Application for Removal or Variation of a Condition following Grant of Planning Permission or Listed Building Consent

Chelston Road

Erection of a two storey side and rear extension

76975/APP/2022/71

Drawing
Proposed Floor Plans

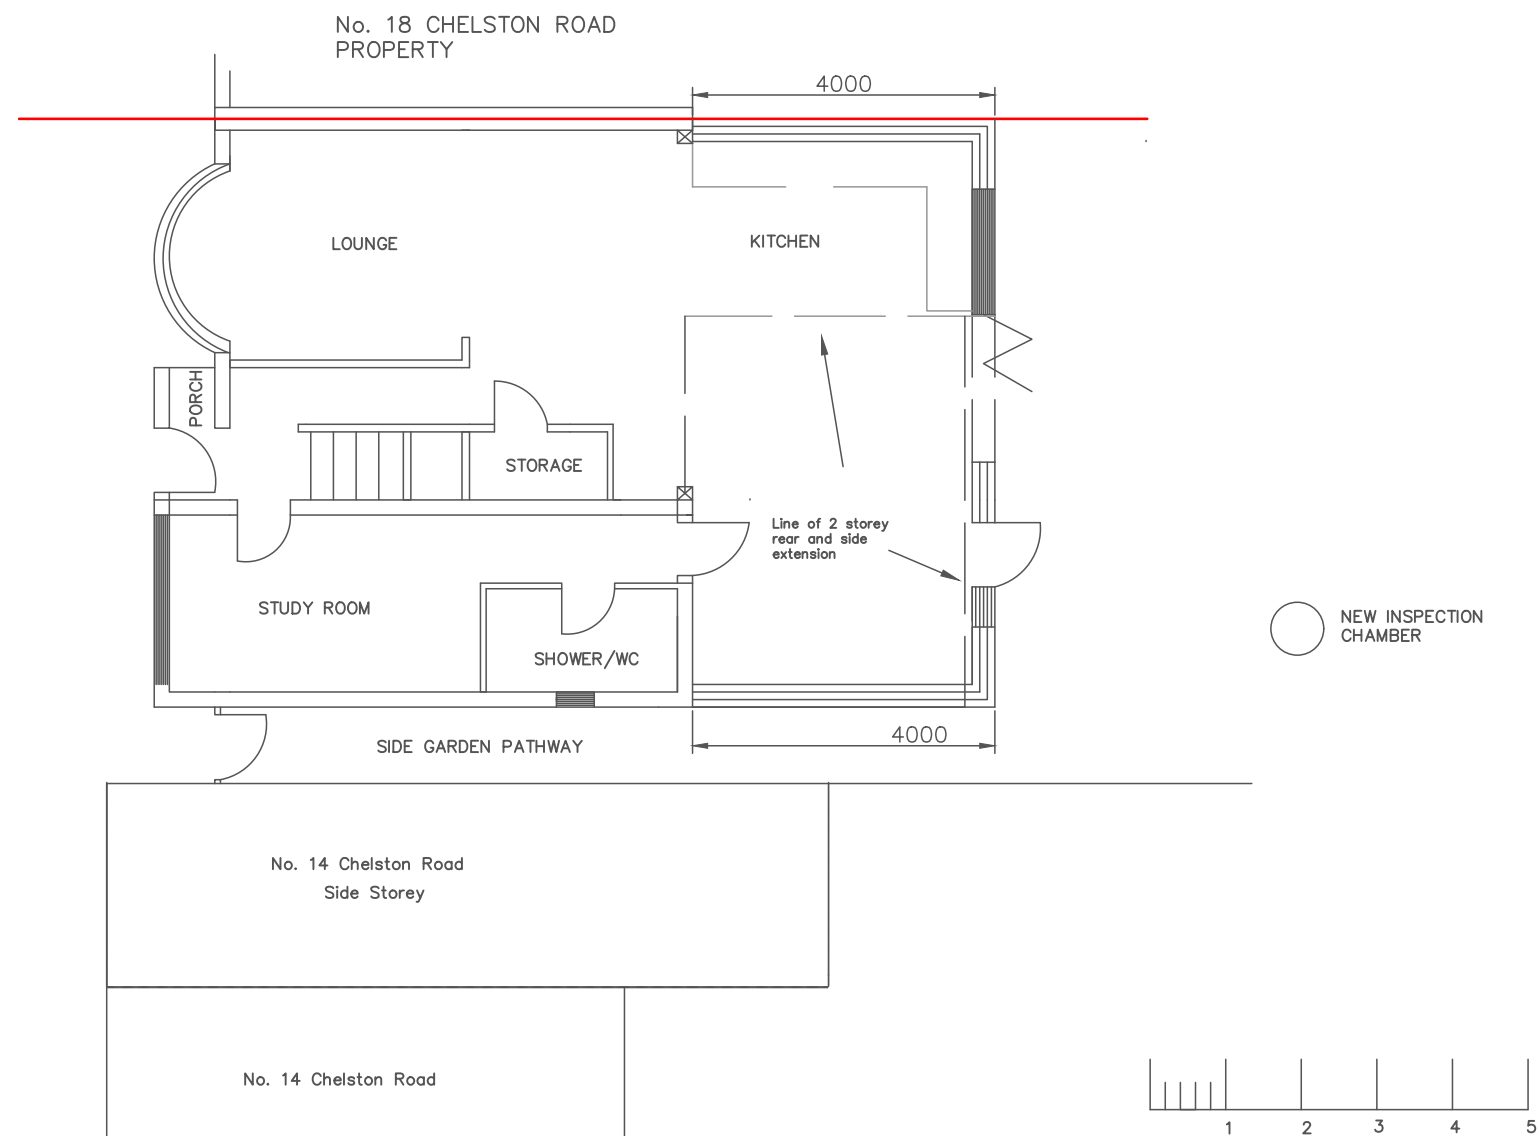
Due to a slight change in the internal layout of the house, we now have two bathrooms on the first floor (on the side of the wall facing Backside garden pathway and No.14 neighbours single storey side extension). We have been advised to install obscure windows with opening 1.7m above floor level by building inspector for each bathroom for air circulation purposes. All windows on the side extension will be obscured, thus not impacting the neighbours' privacy. Please see the updated drawing for further information. Note: This variation follows the same layout as the recently approved planning permission for another house on the road (No. 54 Chelston Road) - Application Ref: 3085/APP/2023/347. (see proposed amended side elevation plan)

Inclusion of additional bathroom obscure windows on the side storey wall with windows opening above 1.7m from Floor level facing backside garden pathway.

Proposed Front and
Rear Elevations

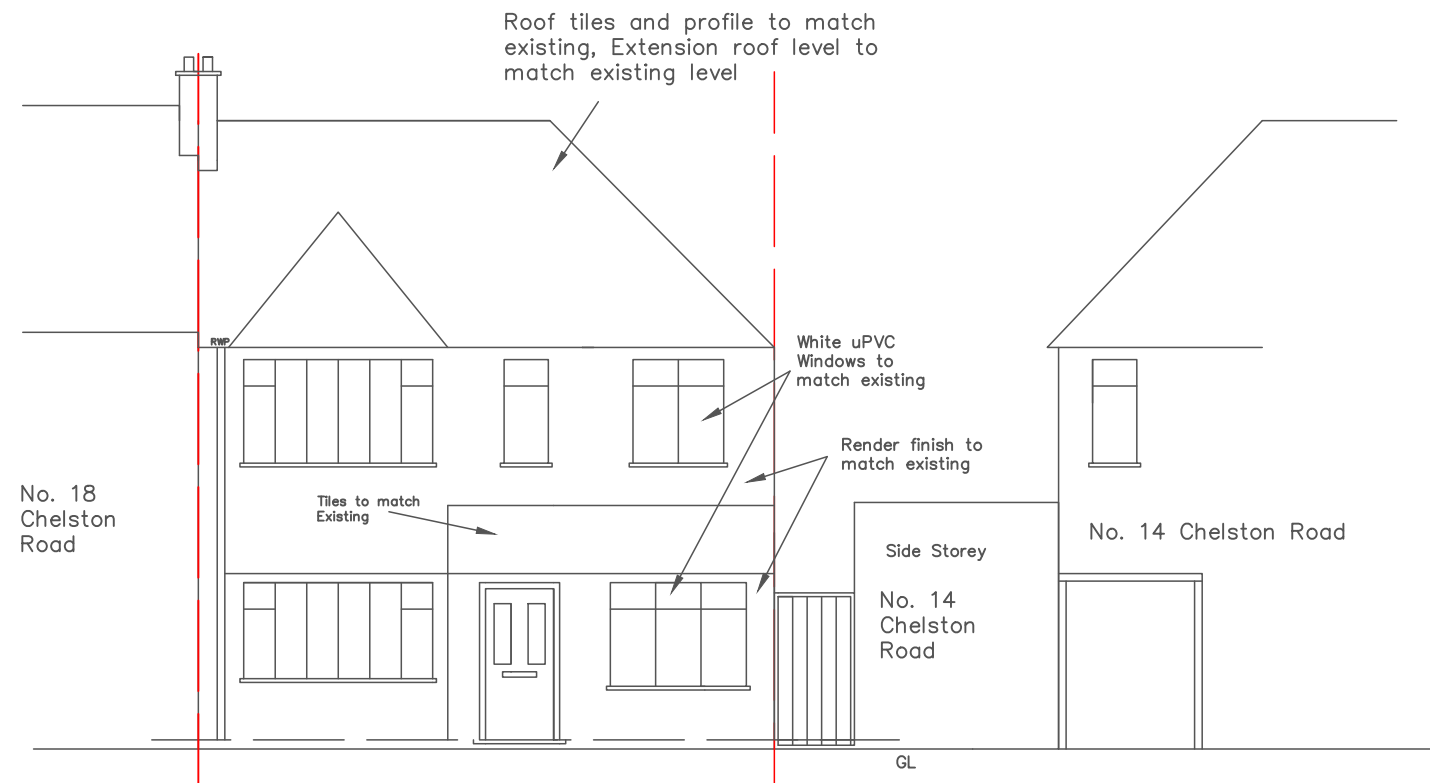
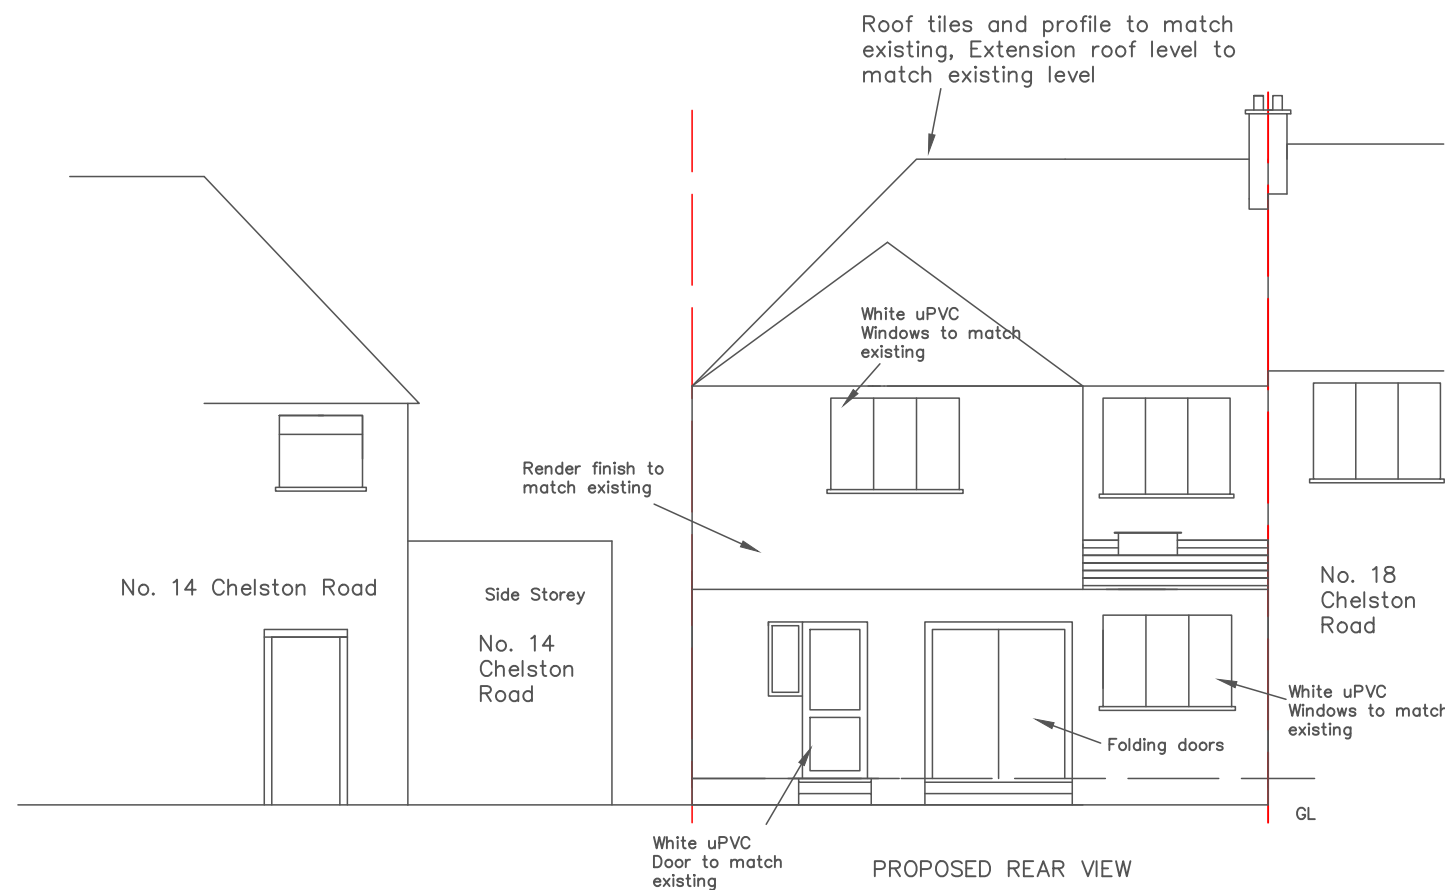
In addition, there is a pitched roof on the single rear extension with a roof light. This was not clear in the original plan. Please see the attached updated drawings.
